From: Local Development
Sent: 12 September 2023 09:17
To: DCAdmin
Subject: FW: Planning Application 2023/62/92066/E

Sent: Monday, September 11, 2023 5:55 PM
To: Local Development <Local.Development@kirklees.gov.uk>; Planning Portal <Planning.Portal@kirklees.gov.uk>
Subject: Planning Application 2023/62/92066/E

I am writing to object to planning application 2023/62/92066/E.

Site Plan 1:200

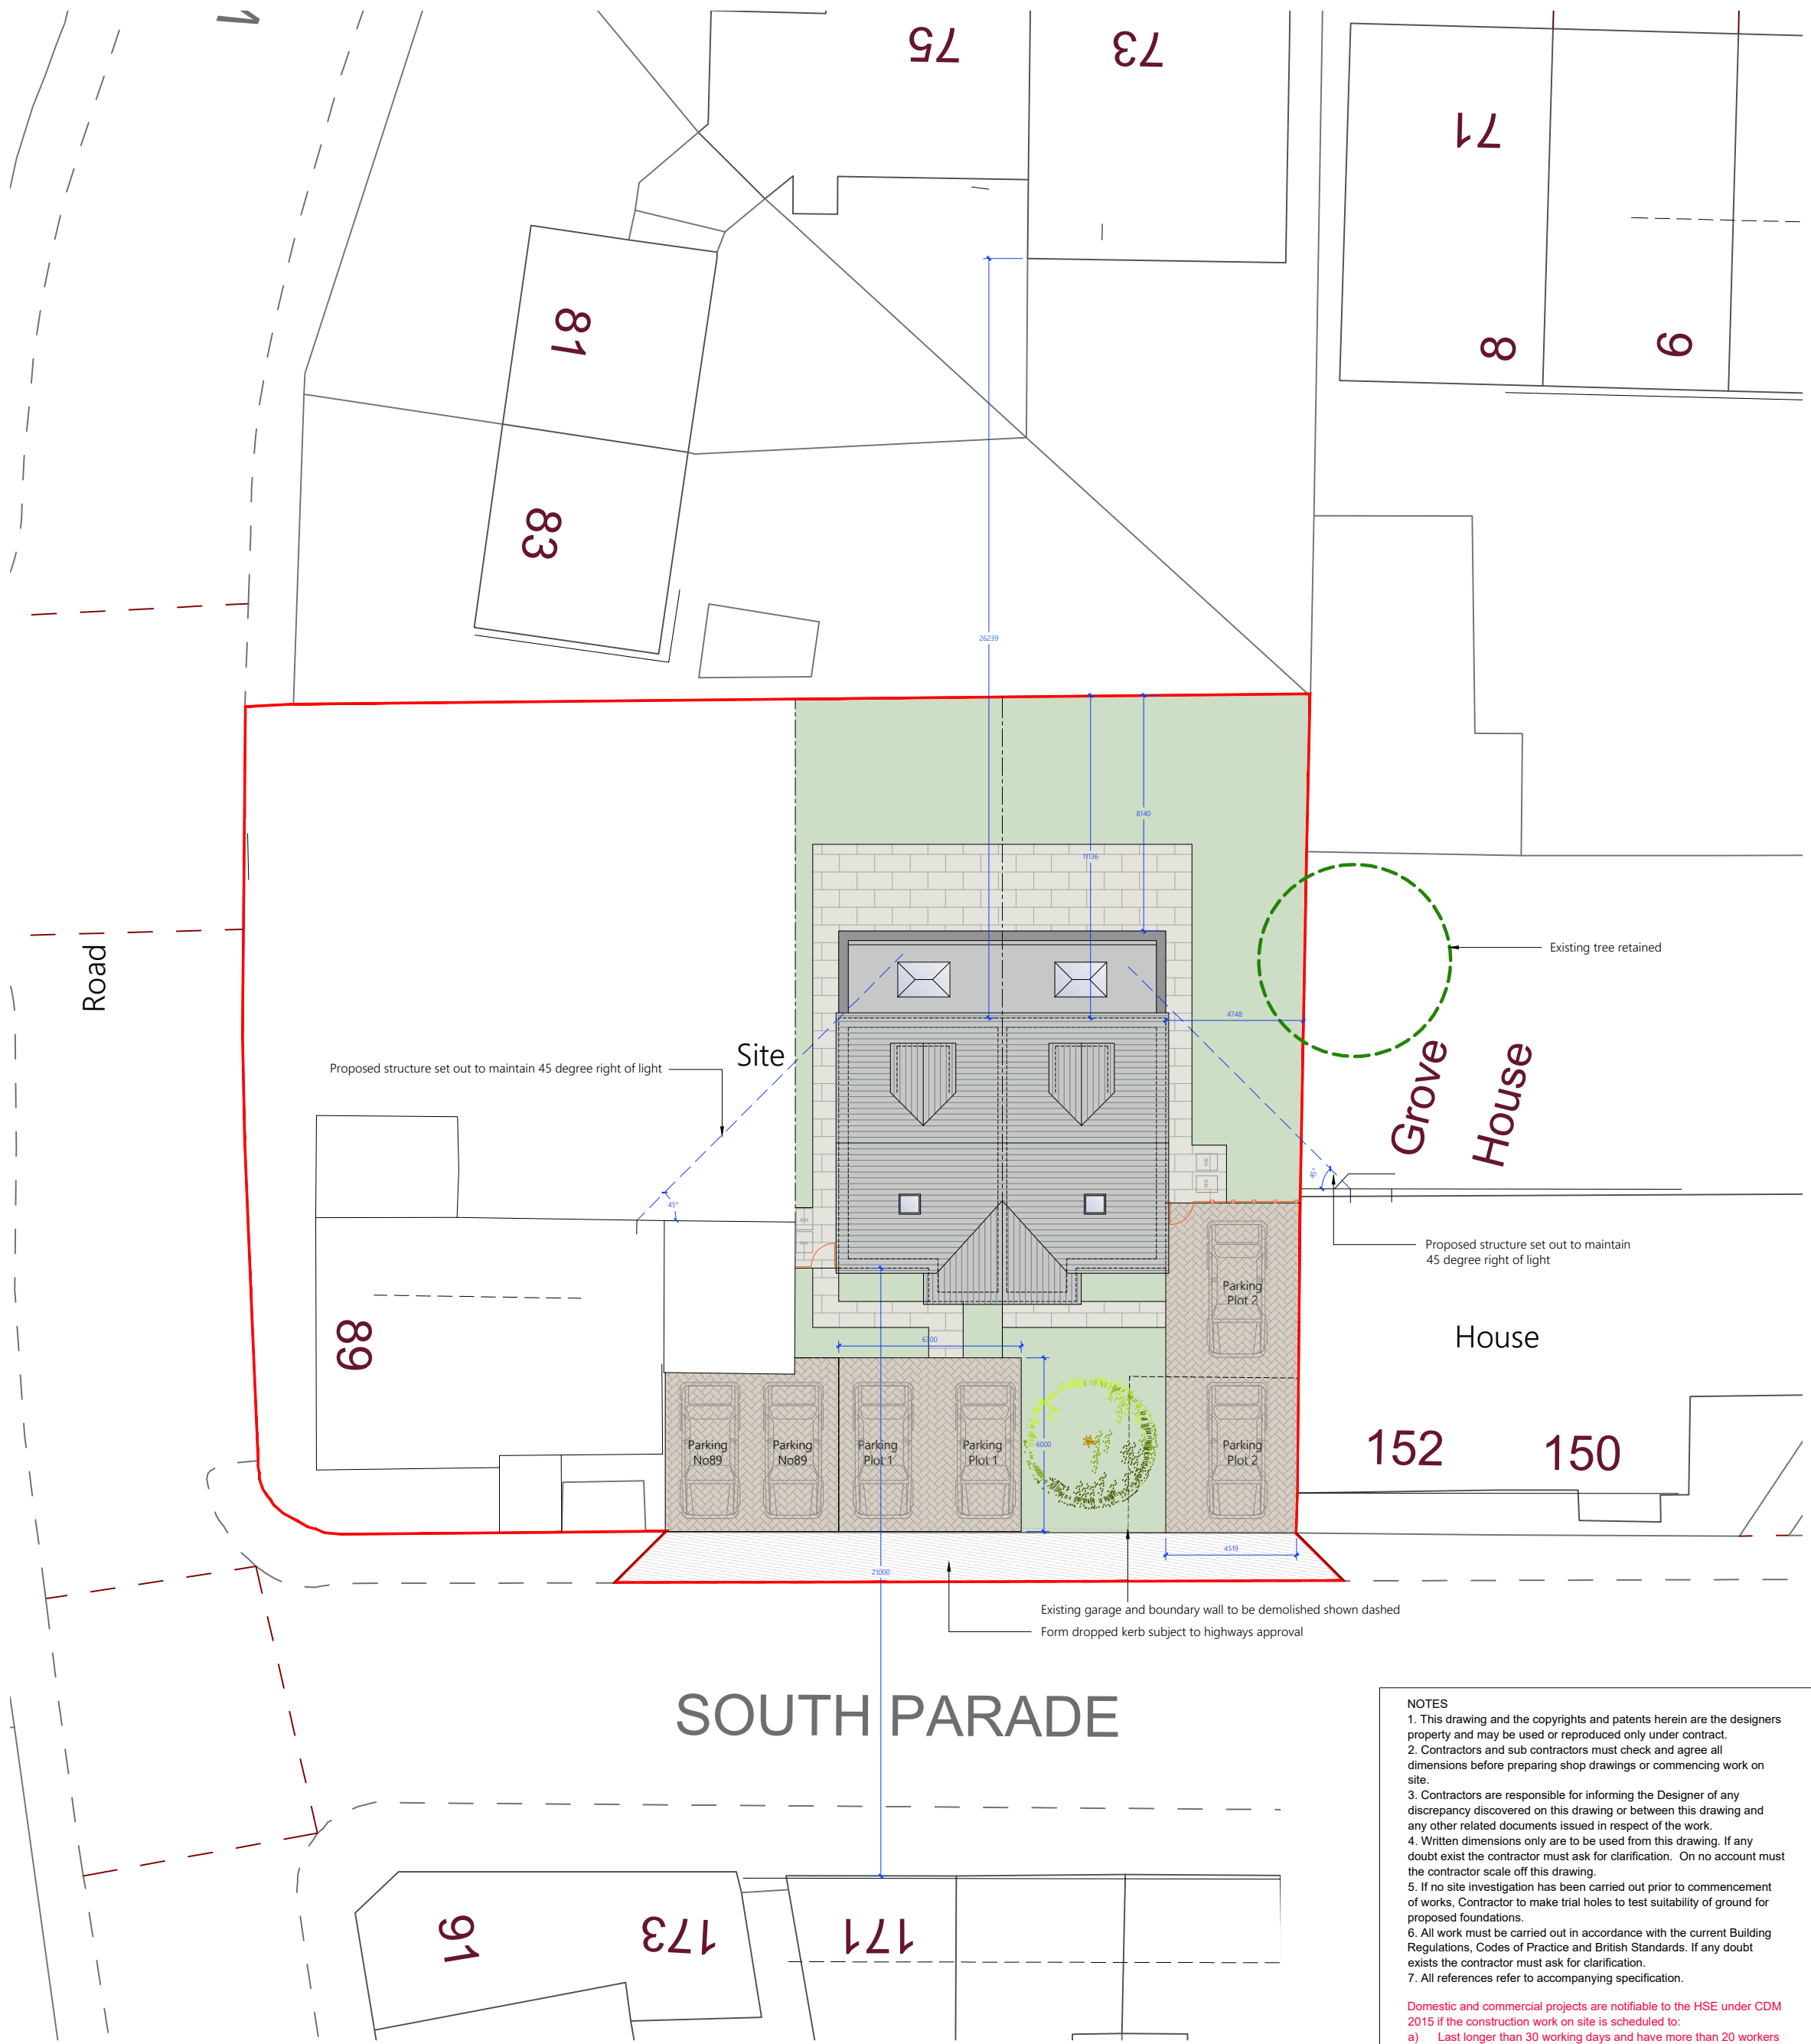
The current plan creates six parking spaces for the existing and new residents of the two houses being built, but it removes as many street parking spaces from South Parade as it creates for the new houses. The plan also underestimates the number of vehicles per household - the existing house is larger than a three bed, so will need more than two spaces and the average three bed house these days is also likely to have more than two cars. The additional vehicles will expect to use street parking, adding additional pressure to the existing and reduced residents parking.
